WEST SUSSEX COUNTY COUNCIL CONSULTATION

TO:	Arun District Council FAO: Mr S Davis
FROM:	WSCC - Highways Authority
DATE:	9 September 2019
LOCATION:	Rear of Inglenook Hotel 253-255 <u>Pagham</u> Road <u>Bognor Regis</u> <u>PO21 3QB</u>
SUBJECT:	<u>P/58/19/PL</u> Erection of 9 No. dwellings with associated access, parking, cycle & refuse storage & landscape design. This application is a Departure from the Development Plan & may affect the setting of a listed <u>building</u> . Additional information received.
DATE OF SITE VISIT:	09/09/2019
RECOMMENDATION:	No Objection
S106 CONTRIBUTION TOTAL:	n/a

Refuse Vehicle
Swept Path Analysis

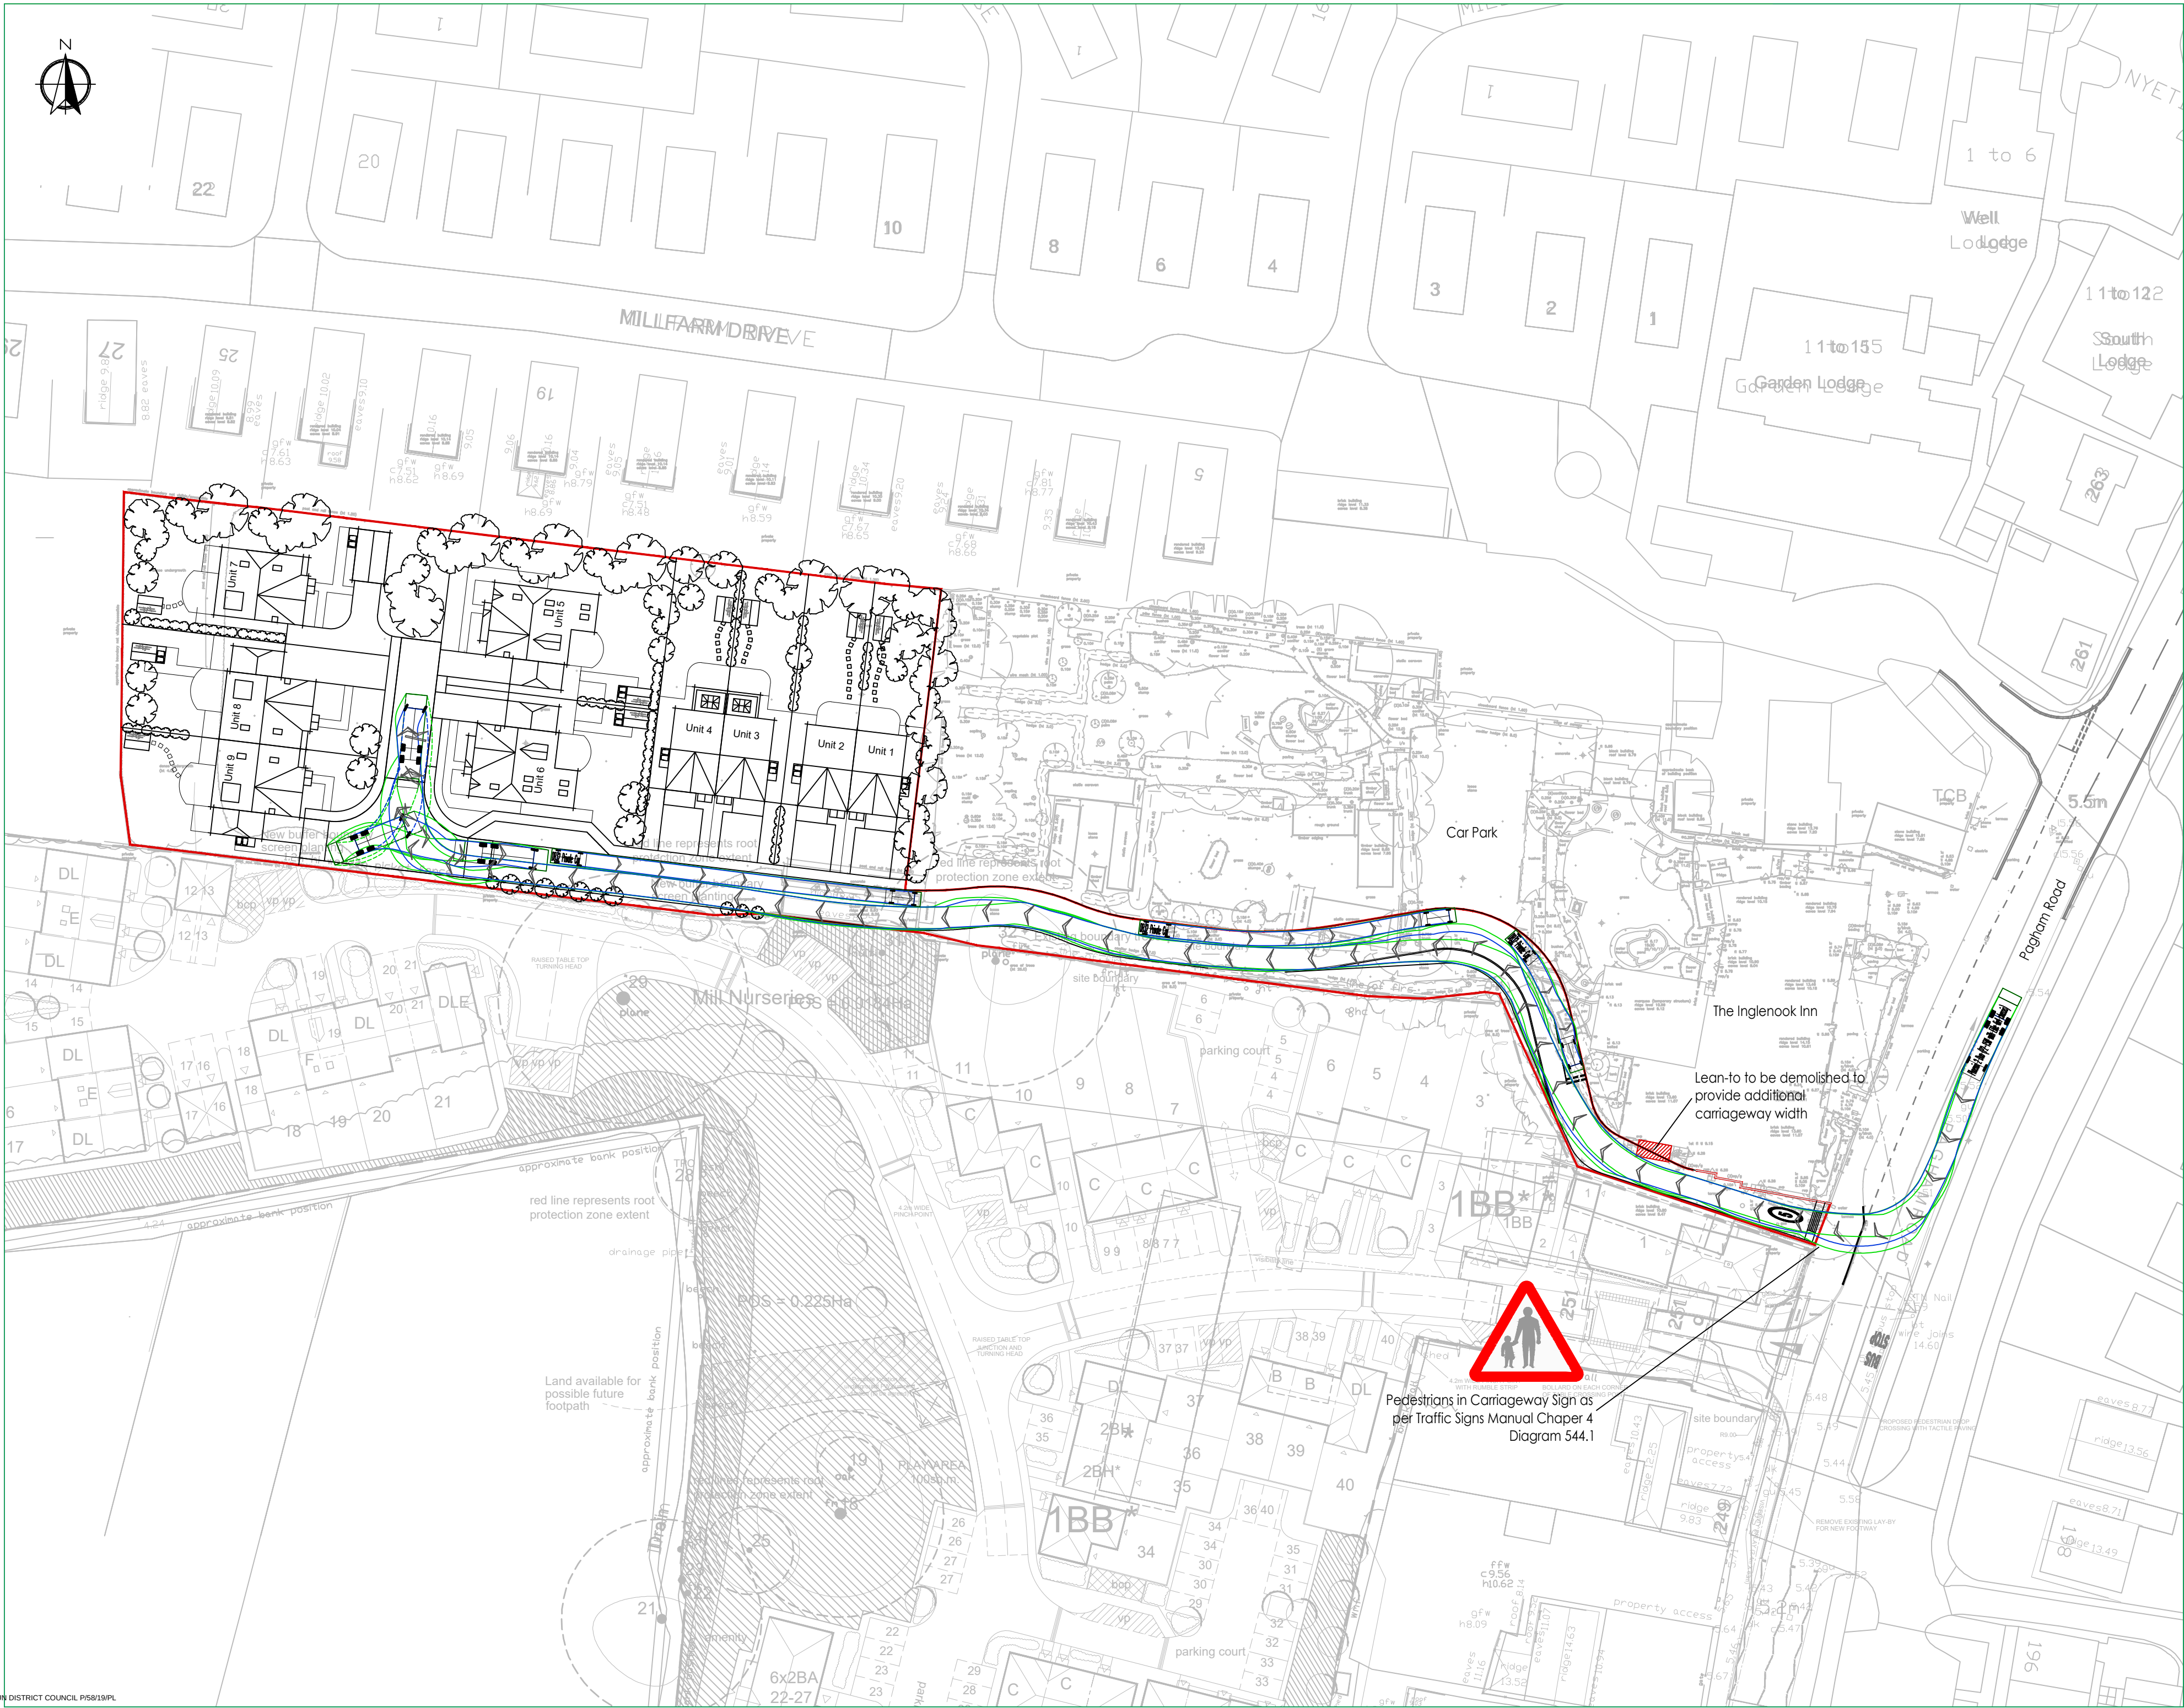
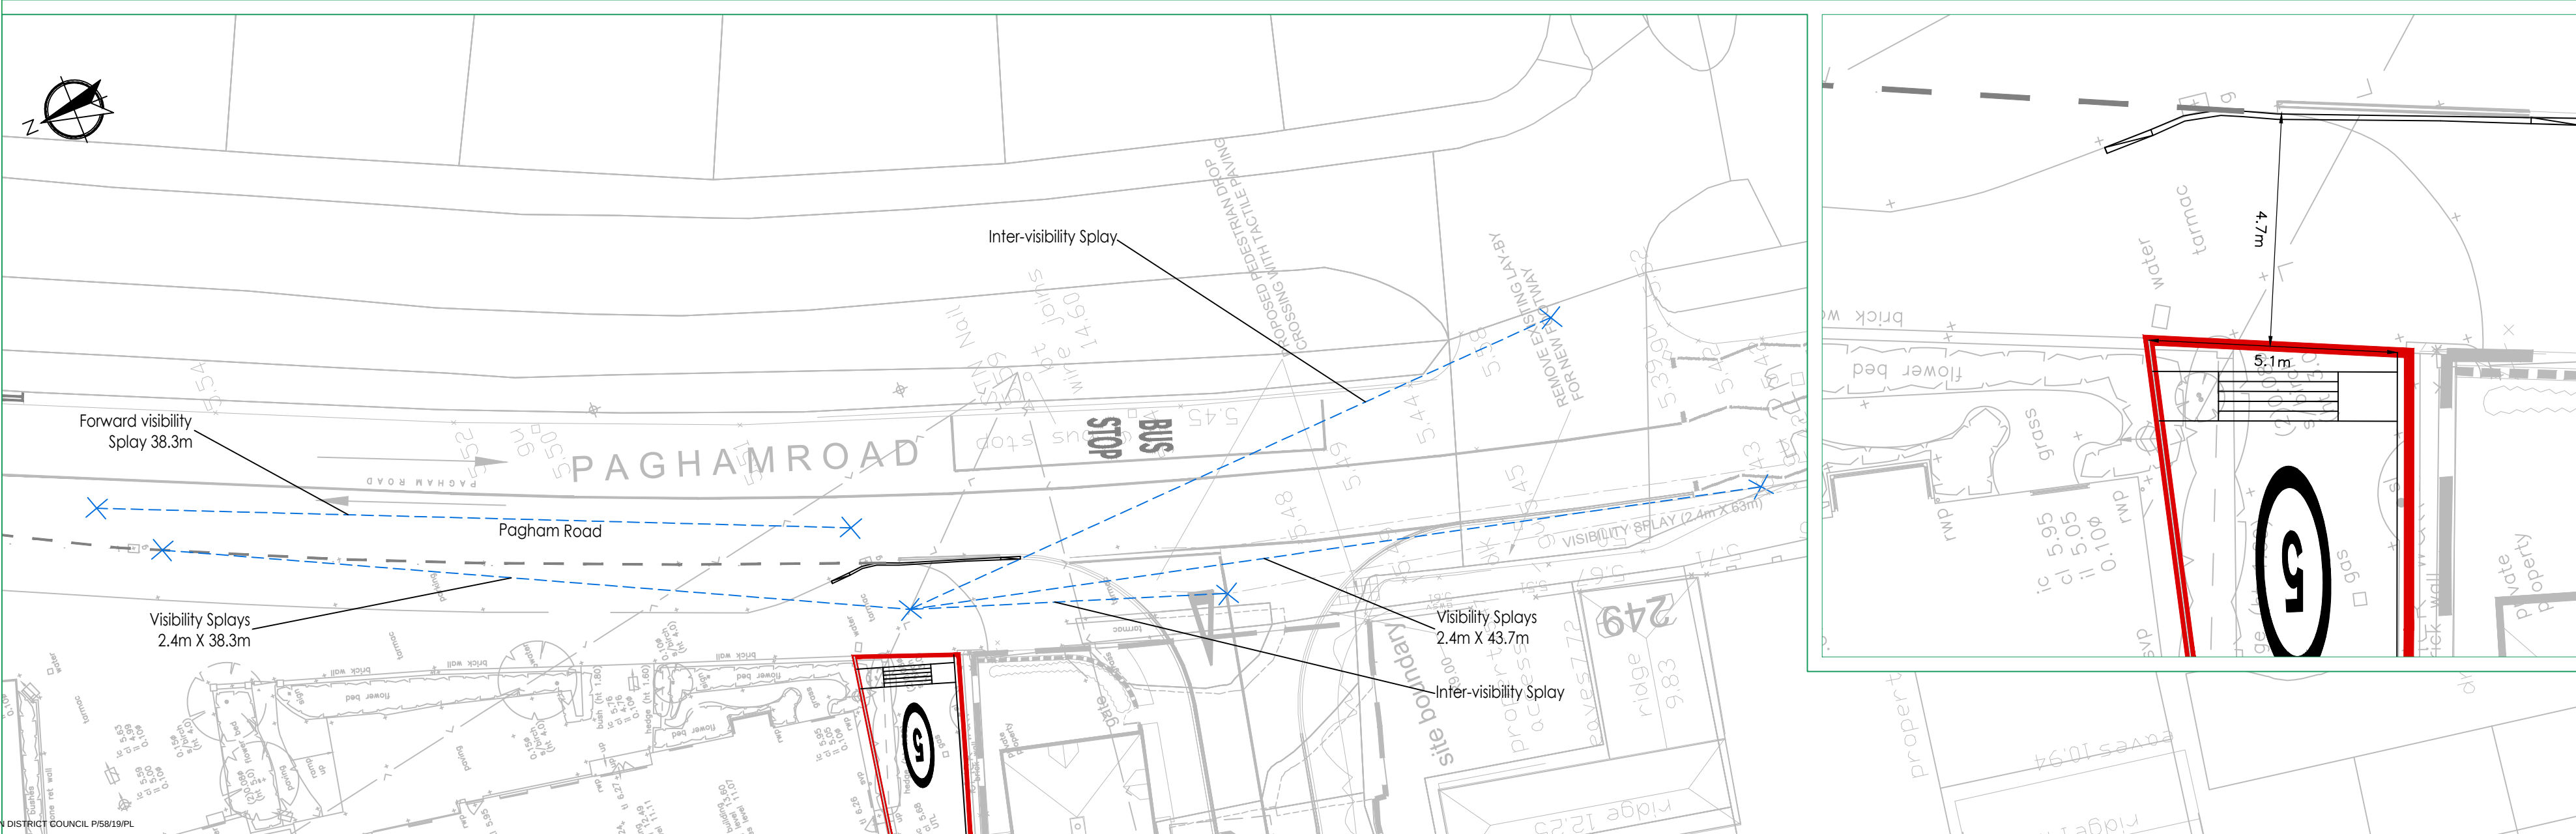
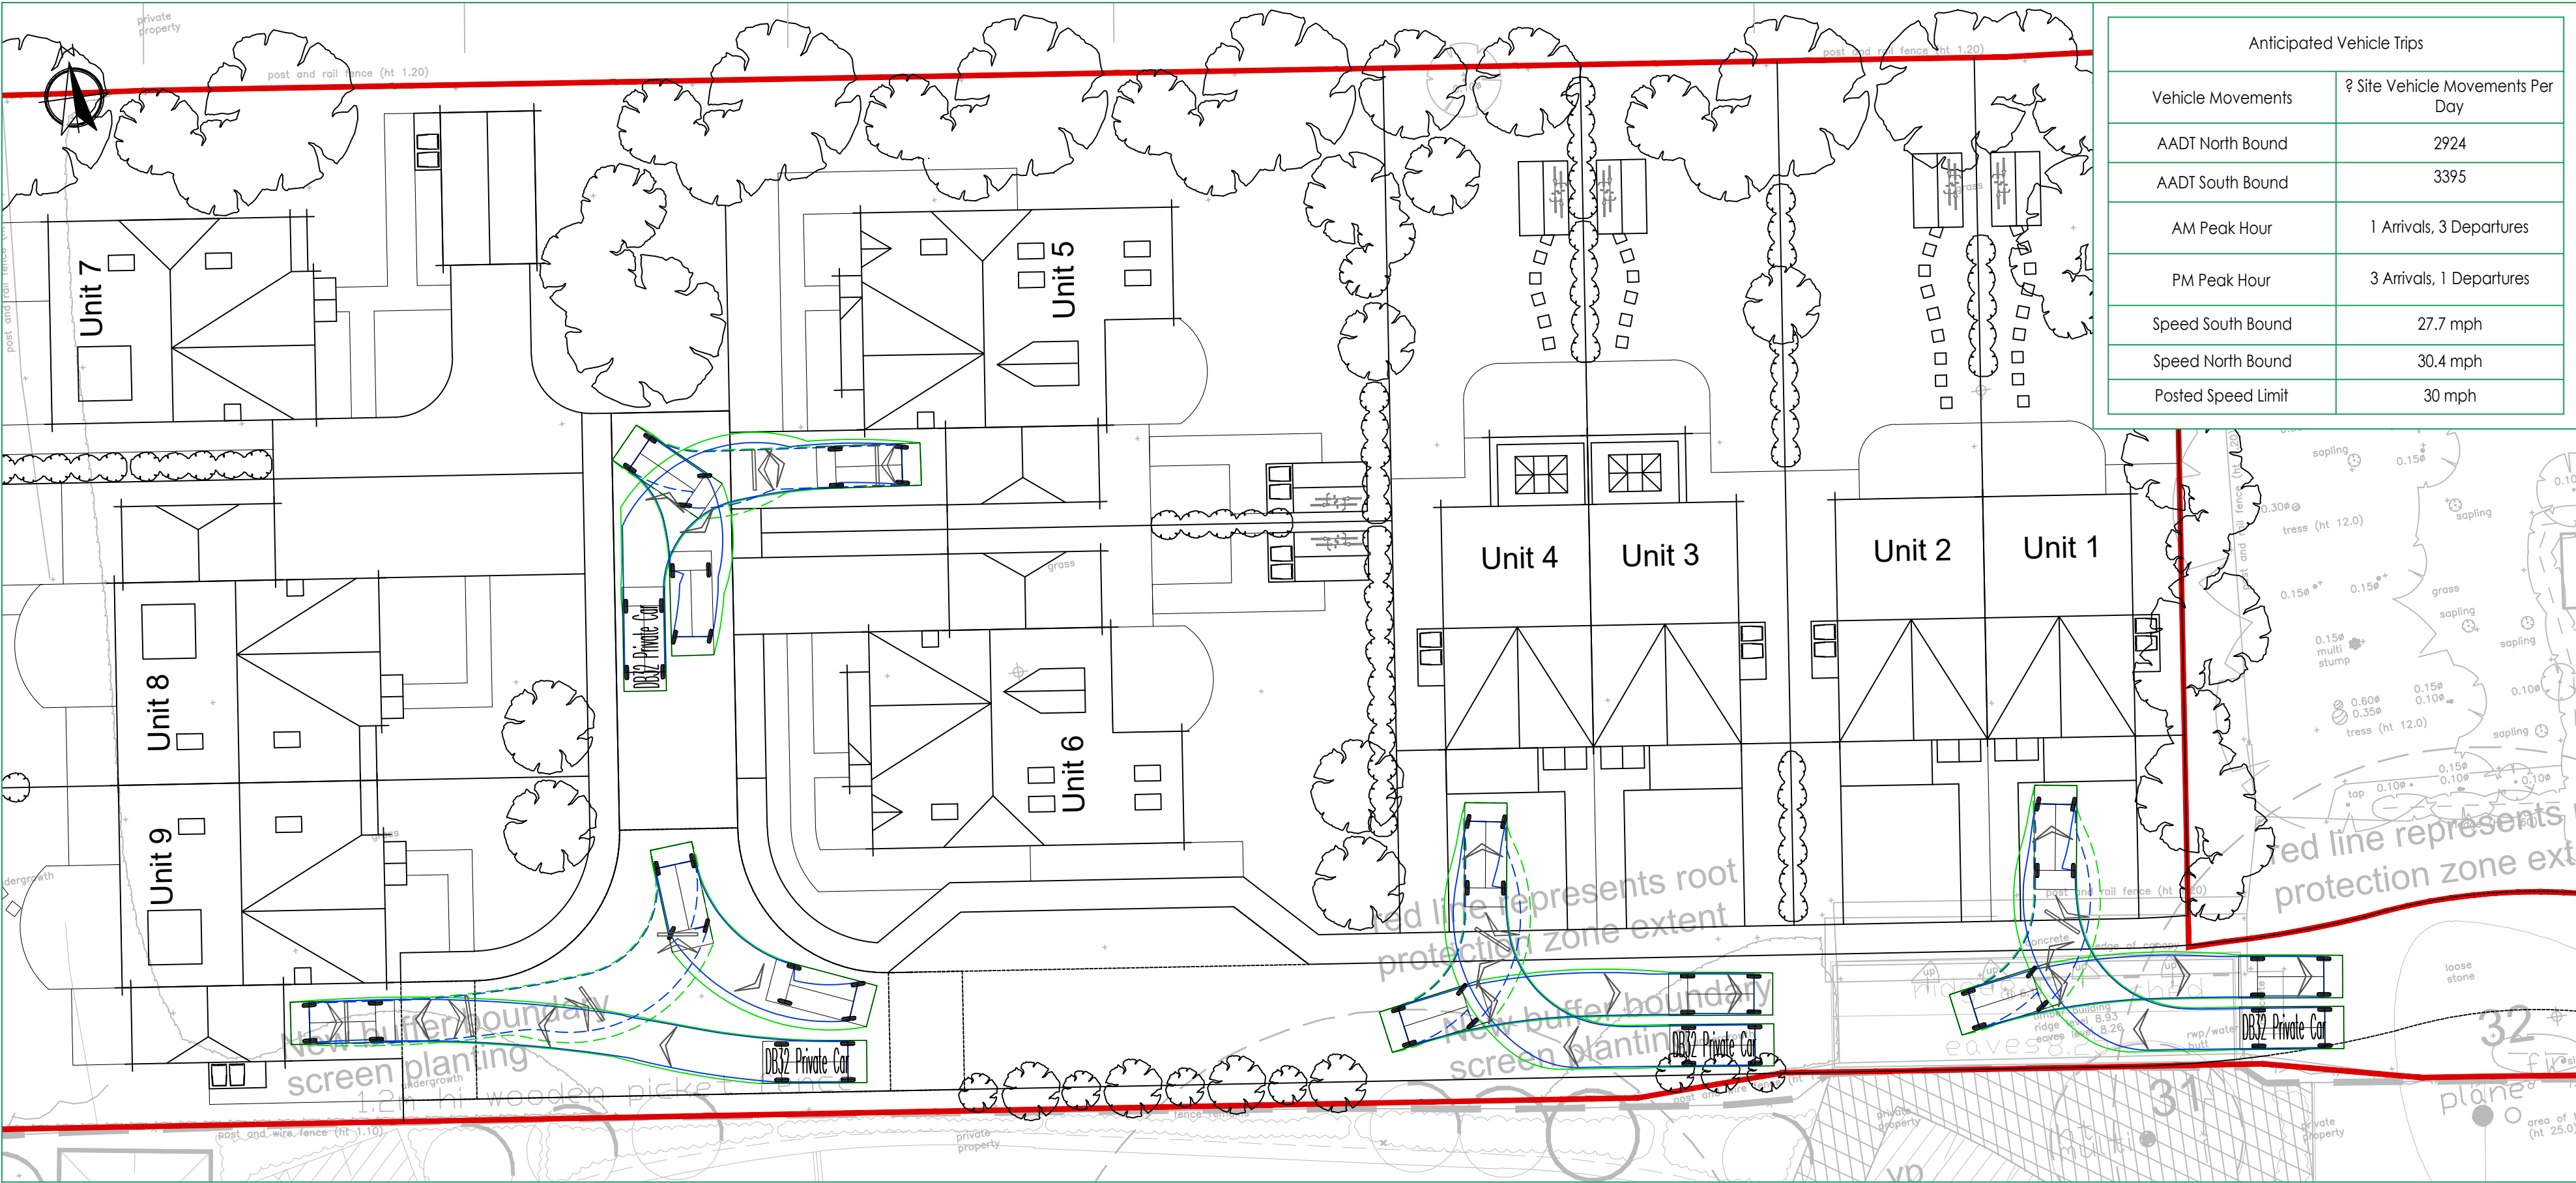
The swept path diagrams have shown that a priority arrangement will operate within the access route; this enables a single vehicle to proceed along the access route whilst a waiting vehicle is clear of the oncoming vehicles' path. The access arrangements would be considered suitable for the use as this is considered a low impact development. The width of the access route will be 5.3m wide with the narrowest parts measuring 3.5m wide.

As previously advised, the Arun Cleansing team have advised informally that there are no severe concerns with the routing of refuse vehicles for this development. The LHA consider that refuse and recycling collection occurs once a week and therefore is not a regular occurrence within the access route. The diagrams demonstrate that this manoeuvre is possible; it would be the role of the planning authority to assess any amenity impact of this arrangement.

The Area Highways Manager has also advised that the signage outlining pedestrians in carriageway is not required
